Demolition of existing bungalow, detached garage & greenhouse & erection of 1 No dwelling, garage & garden shed (resubmission following M/24/14/PL).

6 Alleyne Way Elmer Middleton-on-Sea

Thank you for your internet representation made on 17th June 2015 which has been recorded as '**an objection**' with the comments as follows:

Replacement House
6 Alleyne Way
Elmer Sands
Middleton PO22 6JZ
North & South Elevations

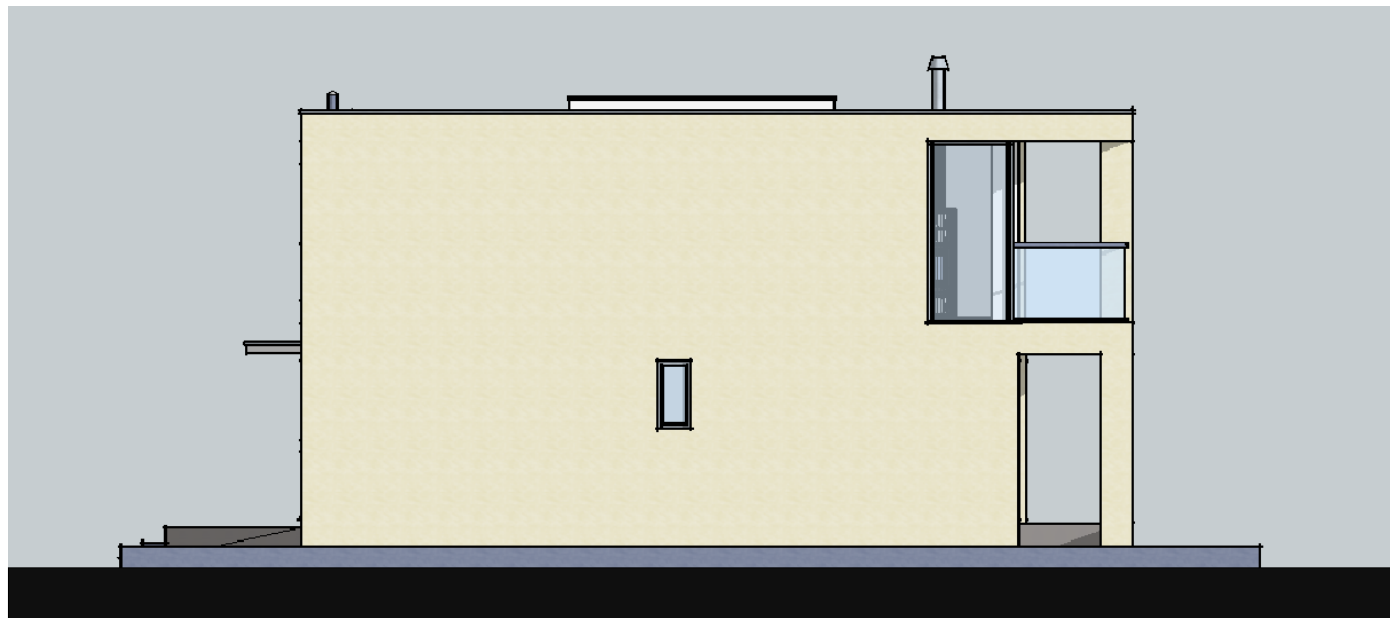
Unless I am missing something I cannot see anywhere in the plans what the height of this proposed property will be. I have always believed that for planning purposes the ridge height needs to be specified and should be restricted to the same height as the adjoining properties. The design and access statement just states the height will be "much in line with neighbouring properties " but it is not clear what this means. After all "Three Decks" one of the properties referred to in the design and access statement is 3 stories! If this development is permitted the height should be limited to that of the adjoining properties.

Replacement House
6 Alleyne Way
Elmer Sands
Middleton PO22 6JZ
East & West Elevations

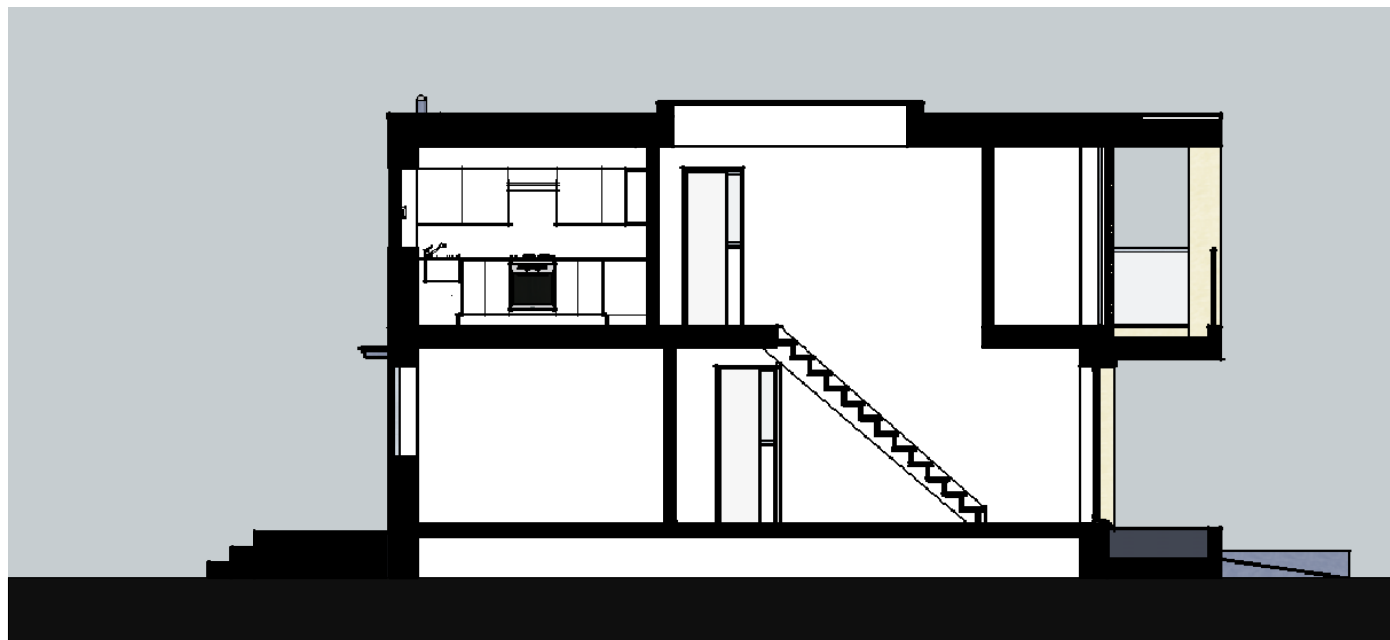
I would ask again that if this development is permitted that the upstairs west facing window should be obscure glass as should the west facing side of the balcony. For the houses on the seafront with balconies most have planning conditions for the sides to be obscure glass to prevent overlooking to the side and I do not see why houses on the opposite side of the road should be any different.
